ABLE MARINE ENERGY PARK

Representation on behalf of the Stone Creek Boat Club by Garry Lyon.

Figure 32.1 Foreshore topography and model boundaries at Cherry Cobb Sands

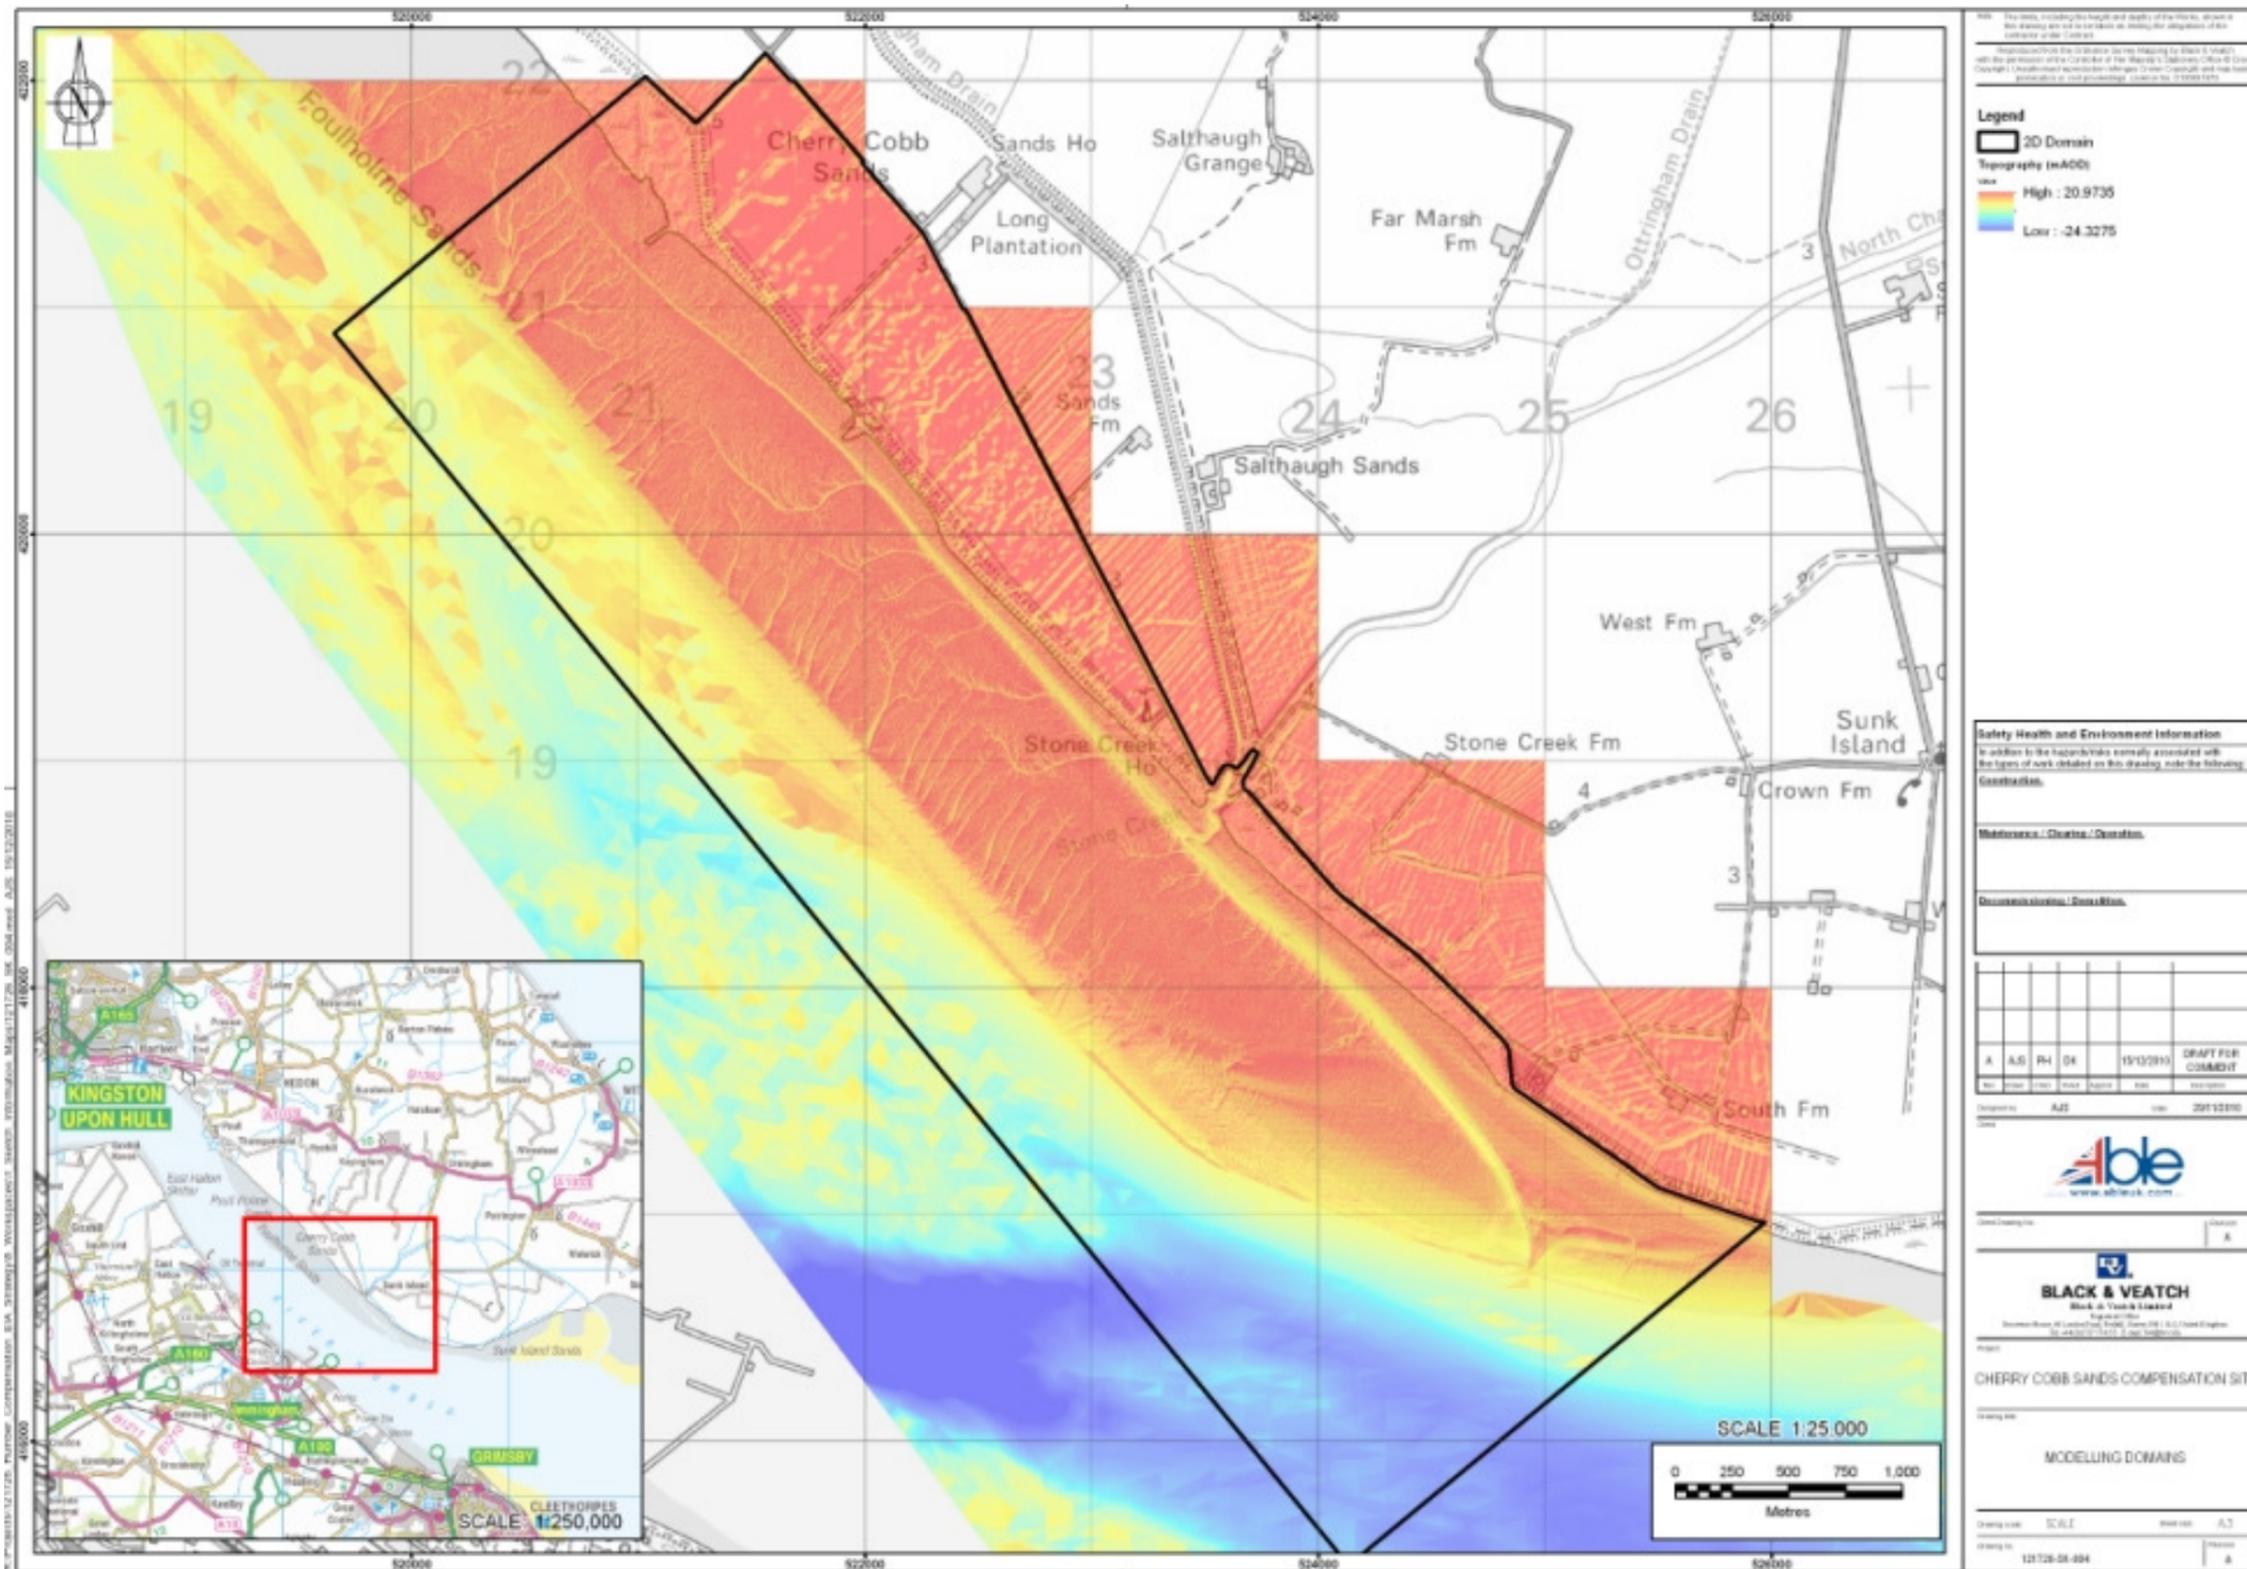
In ABLE representations No. 29.2 and 43.2 and repeated in other responses and within the documents ABLE state:- *Stone Creek which is already subject to maintenance dredging.*

This statement is in error. Stone Creek was dredged following the extraordinary floods of 2007 there has been no other dredging of Stone Creek in at least the previous 30 years. The dredging was a single and unique event and not part of a regular maintenance regime as appears to be suggested.

SCBC has raised concerns about navigation ie available depth of water at the battery and leaving Stone Creek:-

ABLE in their submission suggest siltation and therefore navigation will not be a problem. They offer no remedial action if their assumptions are proven incorrect.

The formation of a new mud bar across the stone Creek outfall.

- *The larger volume of water passing the Stone Creek outfall is likely to produce a high mud bar further impeding navigation.*
- *Any silting up of Stone Creek will reduce water flow out of the level drainage, which will in turn further increase siltation. Photo*

The formation of a sand or mud bar is common when a water flow is impeded by an equal and sometimes opposite water flow. At the point where the two opposing water flows meet an area of still water occurs. When the flow stops any sedimentation carried by the water flow is deposited.

There is an existing mud bar formed at the Stone Creek outfall where the two water channels converge.

Currently the water flowing through the IDB sluice and out of Stone Creek merges with the water flowing down the Inner channel. At present Stone Creek is the more powerful water flow so a mud bar has formed across the inner channel. This bar is 1 to 2 m depending on the cycle of tides.

When the proposed compensation site is operational then priority of the water flows will change. Waters flowing down from the compensation site will form the main flow; a bar will form across the Stone Creek outfall. The height of the bar formed will depend upon the cycle of tides but 1 to 2 m high is not unreasonable.

A Bar forming across the Stone Creek outfall will reduce water flow time and volume.

Reduced flow time will reduce waters draining from the IDB sluice already critical at certain tide cycles and high rainfalls. This was graphically illustrated following the 2007 floods. ABLE mention this but understate the problem.

Stationary or slow water flows will deposit sedimentation affecting Navigation and drainage. Photos 4 No. sluices

- ABLE, before works starts on breaching the compensation site is to carry out a survey to determine and establish the depth of water available in the existing navigation channel out into the river.

This survey, will establish the baseline, '*minimum water depth available for navigation* on a neap tide'.

- ABLE as part of its ongoing commitments is to be responsible for maintaining water depths for navigation to and from Stone Creek and out into the river.
- If, once the compensation site is operational, siltation occurs resulting in a reduction in the '*minimum water depth available for navigation*' then ABLE must take timely remedial action to reinstate the '*minimum water depth available for navigation*'

To remove the risk of any bar forming across the Stone Creek outfall the two water flows merging must be balanced out.

Instead of the current or envisaged situation where the two water flows merge at right angles to each other, the two flows must be encouraged to merge at an acute angle to each other.

Waters could be directed by introducing either a piled wall, baffle or stone cranch. The larger flow down stream from the compensation site would pass the formed channel creating a negative pressure in the Stone Creek outflow. This in turn would encourage greater water flows out of Stone Creek. This system has advantages for all.

To ensure success ABLE would have to give careful consideration to the design and location of the merging baffle.
